Our ref: BMD Response to Comments from ALD on behalf of CPC – 07.02.20

Great Wolf Resort, Bicester **BMD Response to Comments from ALD on behalf of CPC**

The following outlines our response to the comments provided in correspondence of 23rd January 2020 by Applied Landscape Design (ALD) to Clare Whitehead, specifically their review of the LVIA and Landscape Design (following their appointment by Chesterton Parish Council (CPC)) that accompanied application 19/02550/F for the Great Wolf Resort, Bicester.

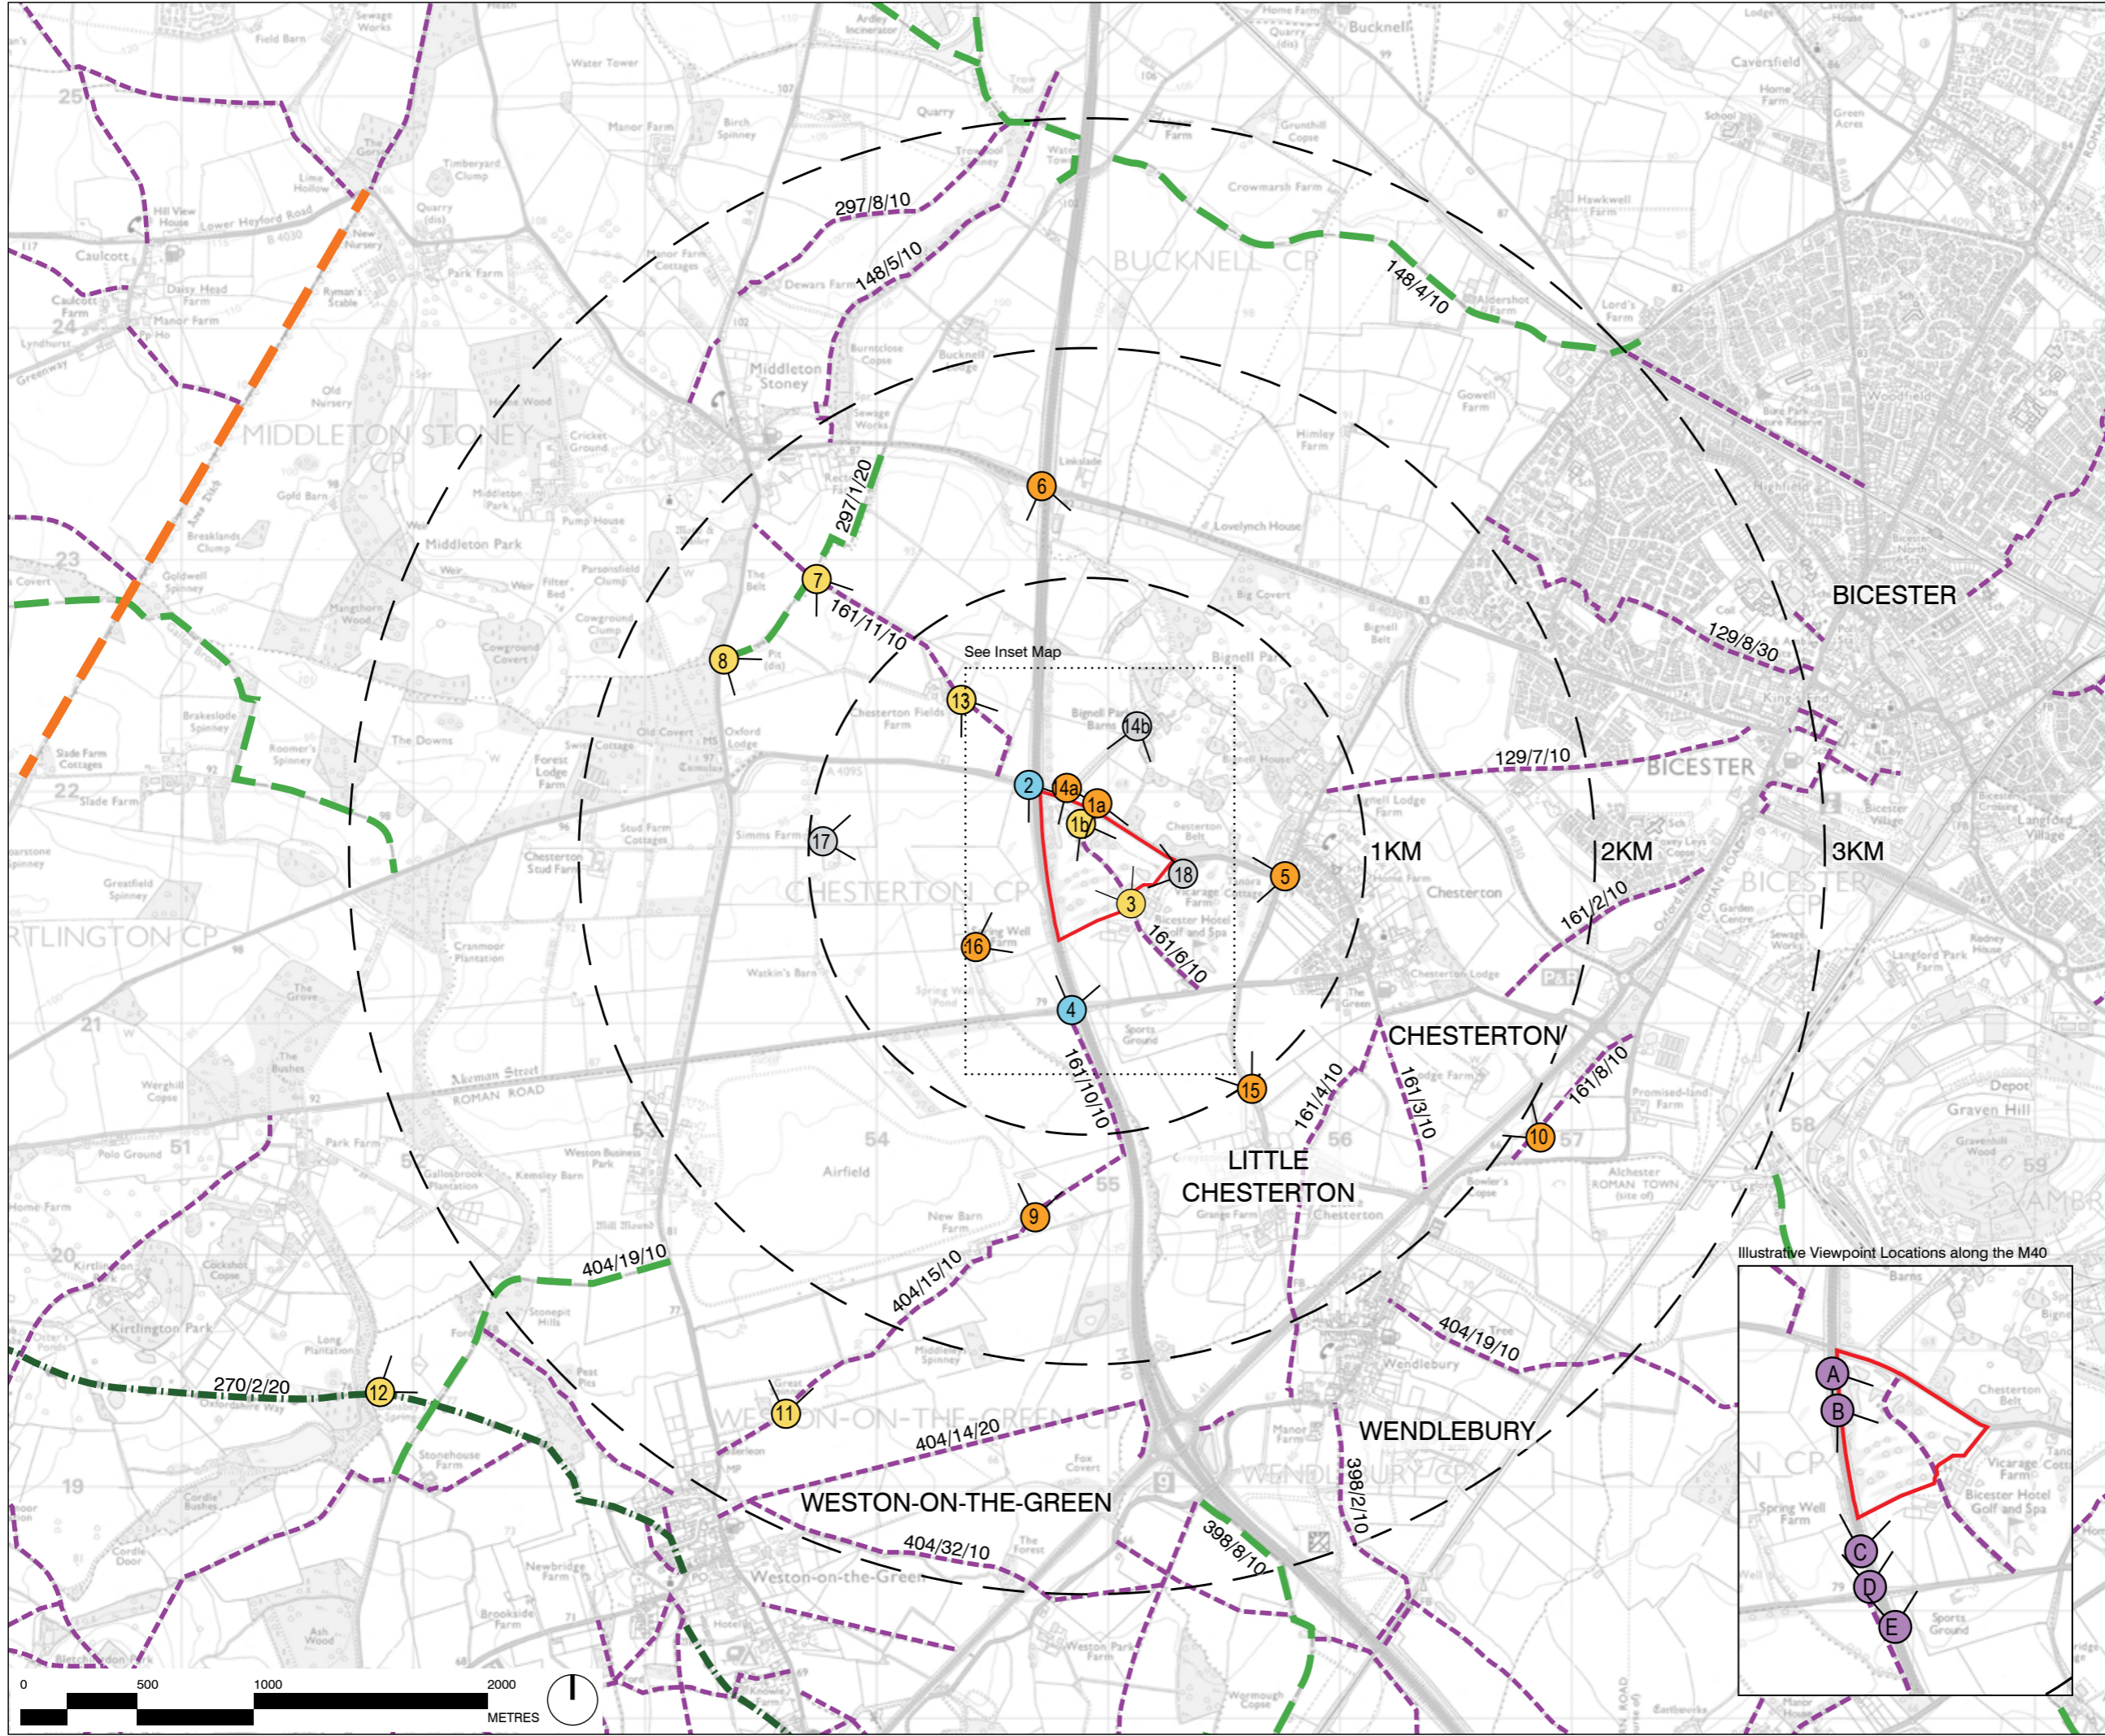
- Viewpoint 1a : ALD noted this is the access point to the public footpath (PRoW) but the LVIA only notes receptors at this location as road users – BMD note that the influence on users of the PRoW was assessed more appropriately by Viewpoint 1b

- Viewpoint 1a Wireframe : ALD suggest that the removal of existing vegetation along the boundary of the A4095 should be represented in this wireframe. This would require a verifiable photomontage from this location, which was not considered necessary or requested by Tim Screen from this location.

- Viewpoints 1b & 3 : ALD raise concern that no AVRs are provided to indicate the built form / massing from these locations. BMD can confirm that, during the scoping discussions, Tim Screen confirmed that a photomontage or wireframe from the PROW was not required as part of the application, as it was clear that there would be a range of views of the proposals from within the site boundaries.

- Viewpoint 2 : ALD query the position of the western site boundary. We can confirm that, with reference to the Year 1 & 15 views in Appendix 13.8, the highway boundary is defined by the existing post and rail fence at the top of the grass bank to the east side of the M40. The variation in planting shown between Year 1 & 15 behind this fence is proposed and would be controlled by the scheme. ALD also raise concerns that this viewpoint illustrates *“a long flat linear structure evident above the tree tops”*. The nature of the structure visible from this location is accepted however, given the low sensitivity of the receptors passing over the M40 and with views of the scheme at this point, the LVIA describes this as a Minor Adverse effect in the short term, reducing to Negligible / Neutral in the long term (as mature woodland vegetation would largely screen views of the development).

- Viewpoint 10 : ALD queried the point of this viewpoint. We confirm that Viewpoint 10 was recorded to represent the view from the footpath to the south east of the site, with the suite of viewpoints representing a range of distances, directions and receptors as required by GLVIA3.

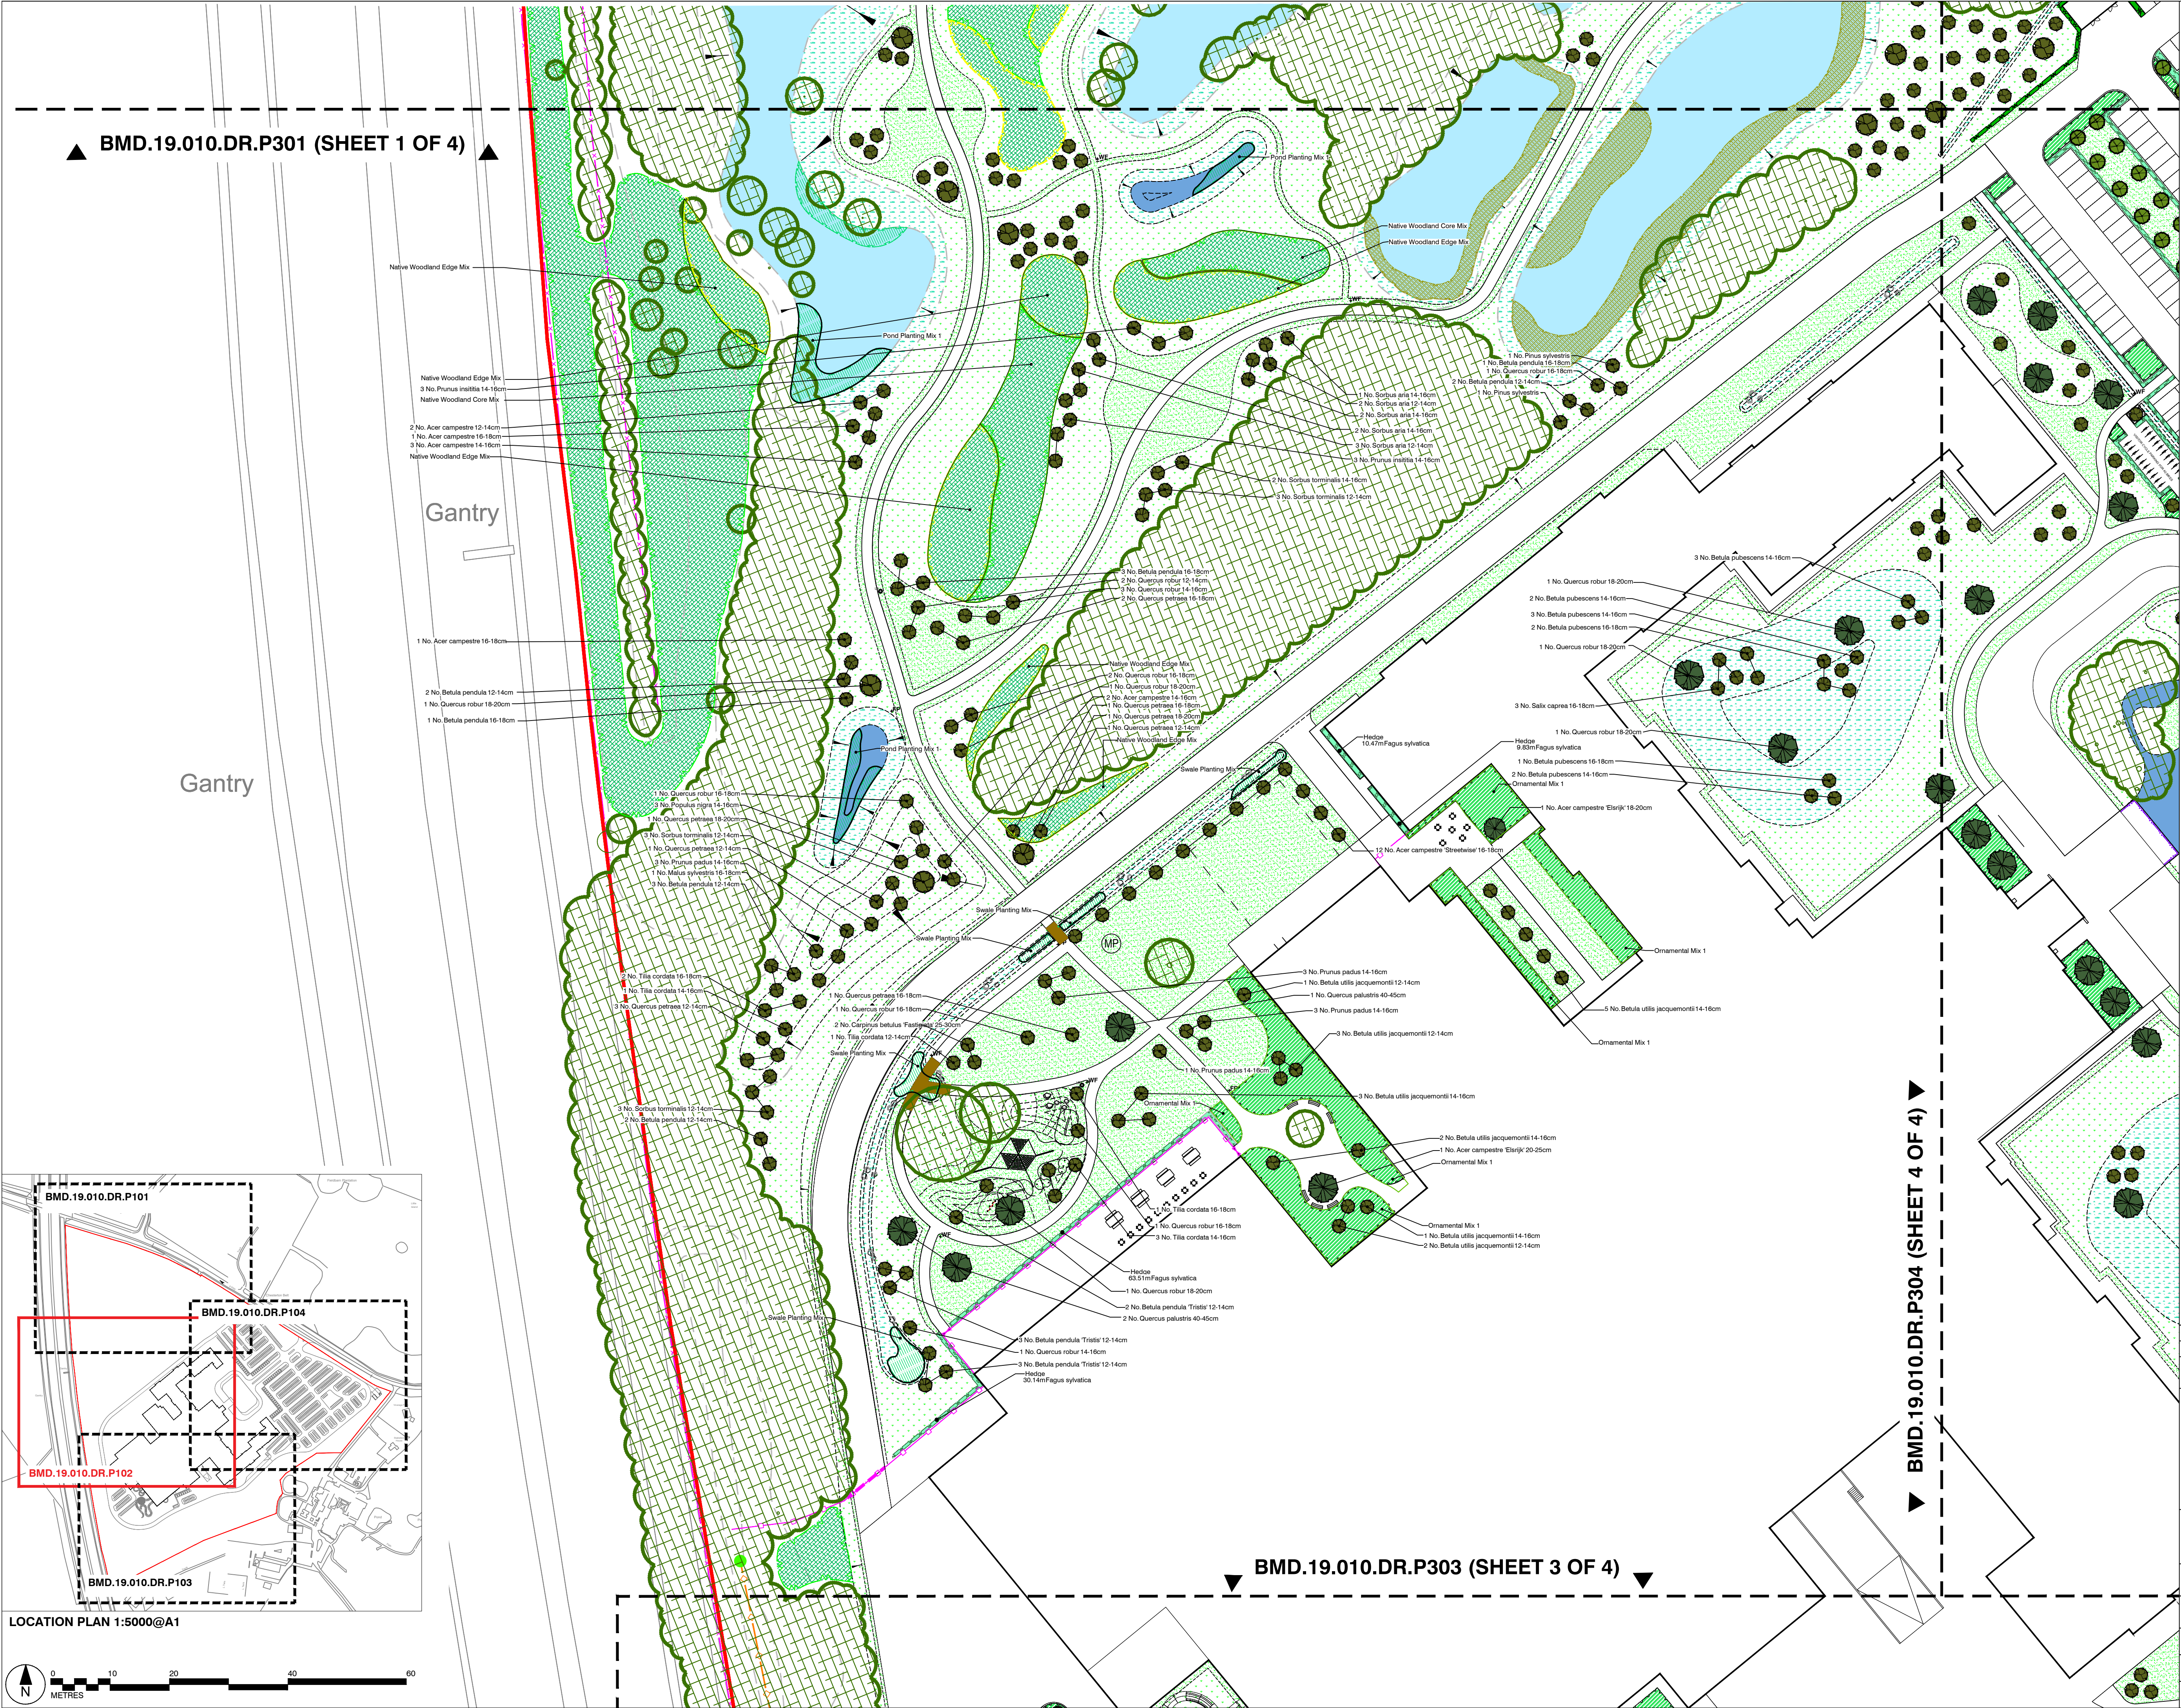
ALD raise queries regarding the proposed realignment of the PRoW, suggesting this is not clear on the Landscape General Arrangement Plans. The alignment of the diverted PRoW is clearly illustrated in the Design & Access Statement at 5.5.3. The existing northern footpath point would be closed, with the footpath diverted through the landscape corridor along the southern boundary of the site as noted above. Permissive access would still be afforded to the public, allowing access into the northern part of the site, via the existing northern footpath access point - but this would provide amenity use of the northern parkland only, with no connection to the diverted public footpath along the southern landscaped corridor. Combined, these proposals are considered to provide a substantial enhancement over the existing situation, as reported in the LVIA.

ALD raise concerns that “*Very few existing trees are indicated to be retained within the site*” suggesting that they are drawn “*with no use of topographic survey information*” and that the “*Existing landscape to be retained particularly along boundaries, including the motorway boundary, is unclear*”. Extensive areas of woodland and trees are proposed for retention as part of the development, particularly along the boundaries and within the large

area proposed for the northern parkland. The footprint of these areas has been drawn based on a Topographical Survey, Arboricultural Survey and current aerial photography of the site - ensuring accuracy and viability of tree stock to be retained. These areas are clearly illustrated on the Landscape General Arrangement and Planting Plans. All areas within the red line boundary are within the site, so would be retained in the long term as part of the proposals. Areas alongside the M40 are also indicated but are not considered necessary to achieve the mitigation required by the LVIA.
